Our Ref: EN010140

### **Application by Enso Green Holdings D Limited for an Order Granting Development Consent for the Helios Renewable Energy Project.**

#### **Advice following issue of decision to accept the application for examination**

Helios Renewable Energy Project
Order 2024
Land Plan (Key Plan)
Document 3.1
Regulation 5(2)(i))

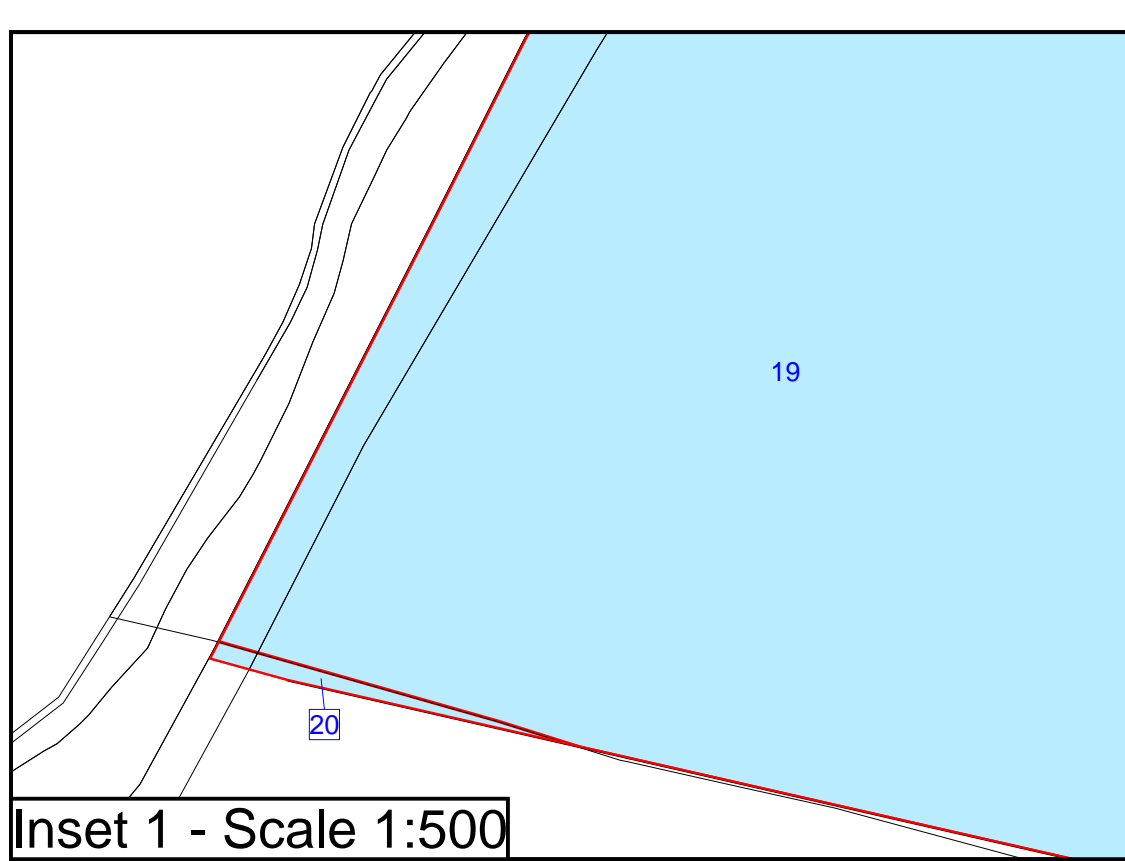
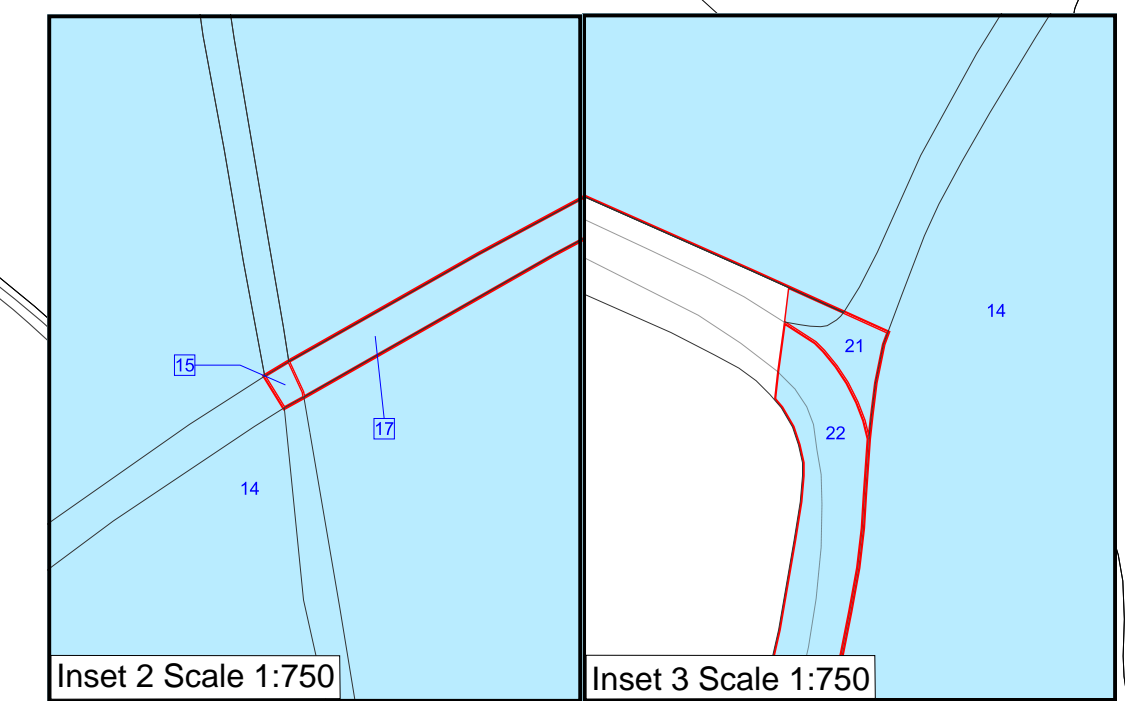
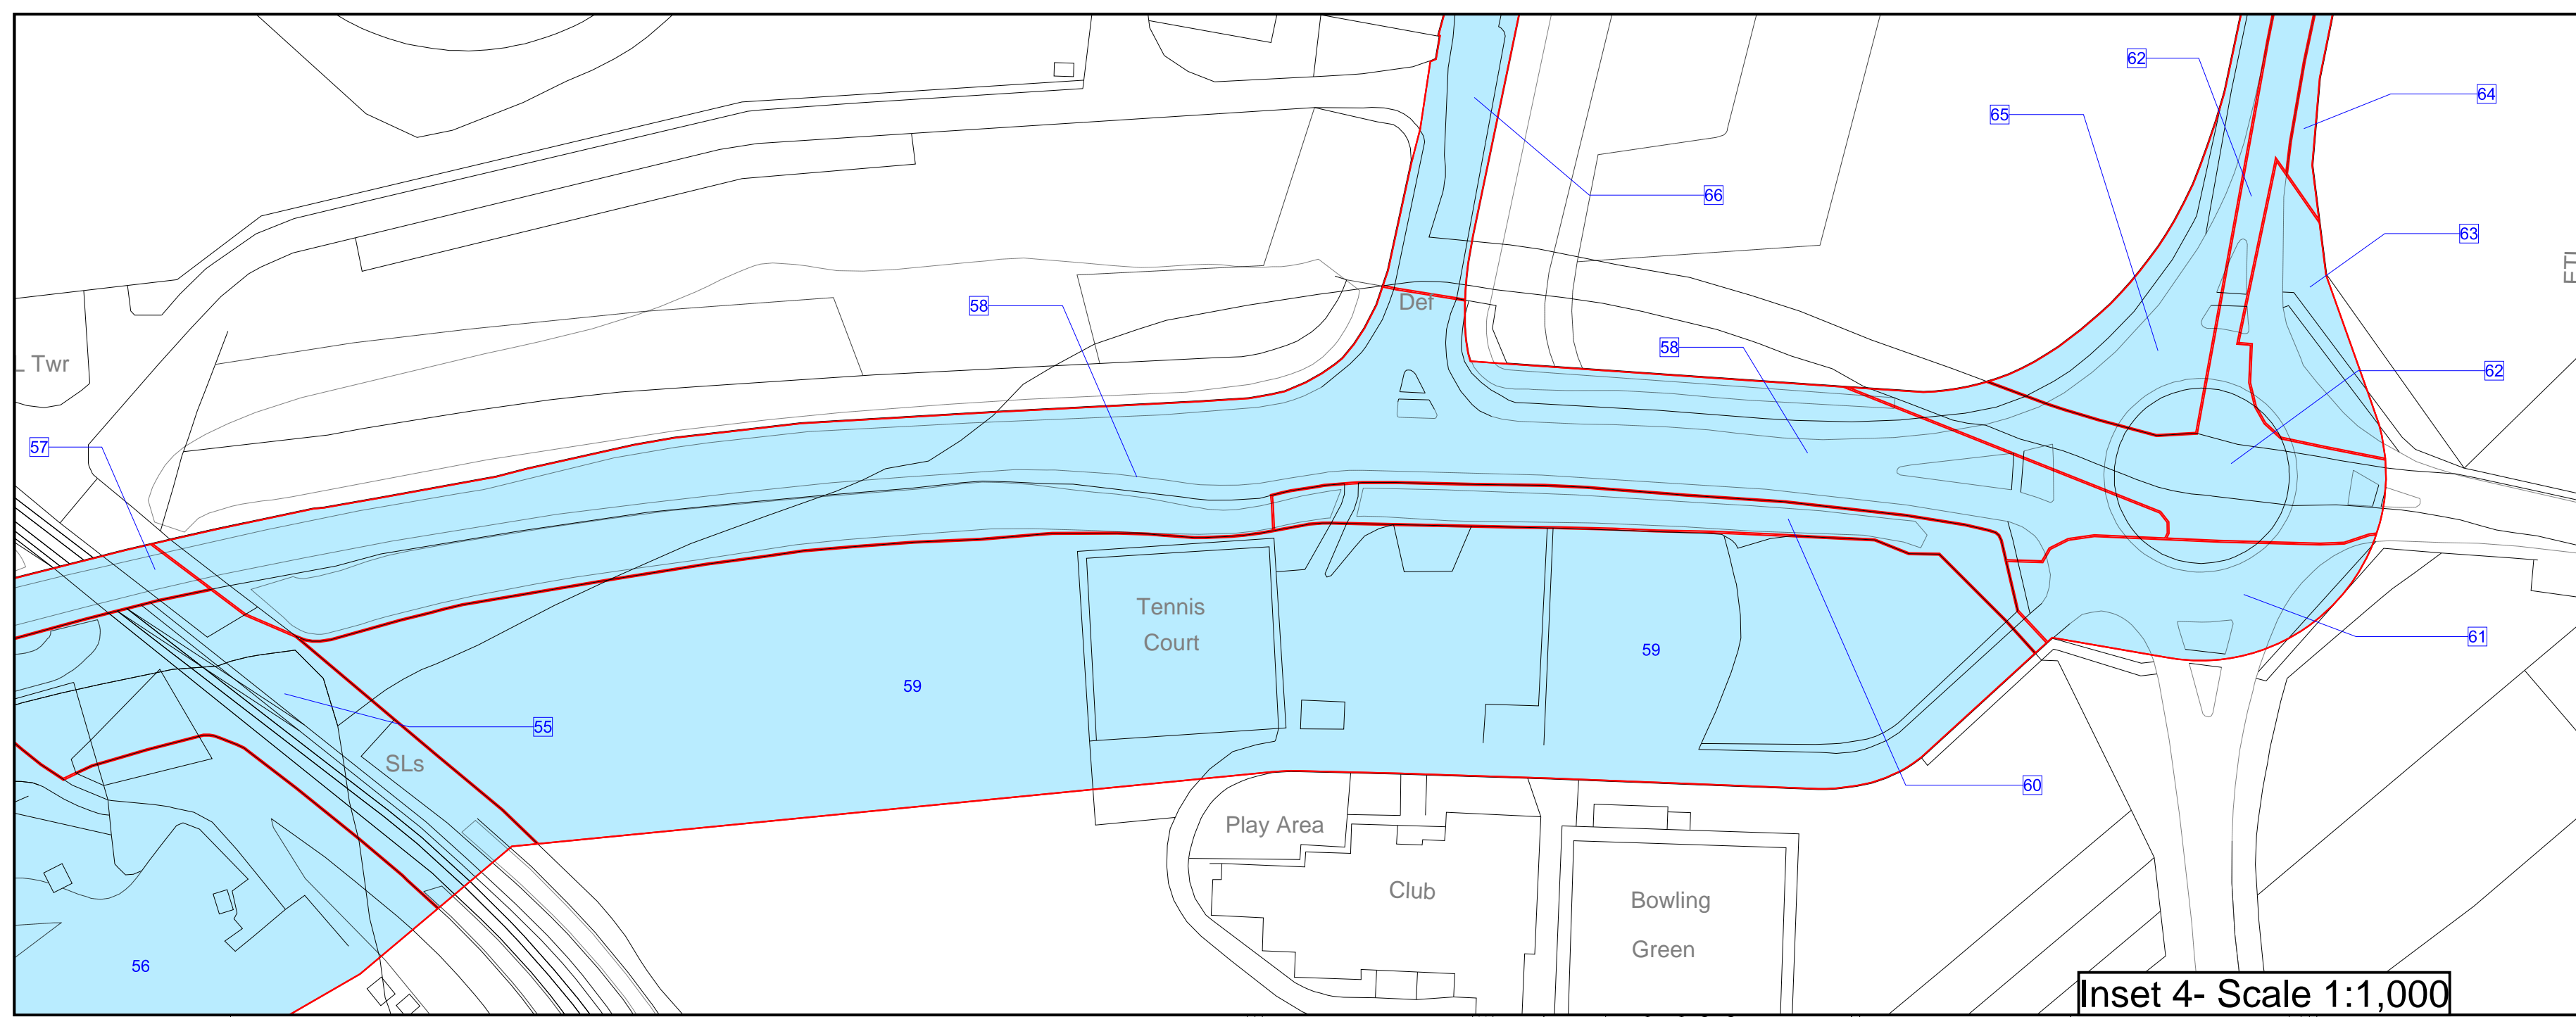
The DCO seeks powers to acquire permanent acquisition of new rights (article 23), acquisition of subsoil (article 26) and temporary use of land to permit construction and maintenance (articles 30 and 31). The land related to all these powers sought is shown edged red and shaded blue on the land plans. Greater clarification as to whether all powers are sought for the whole area or if different powers relate to individual plot numbers would be beneficial.
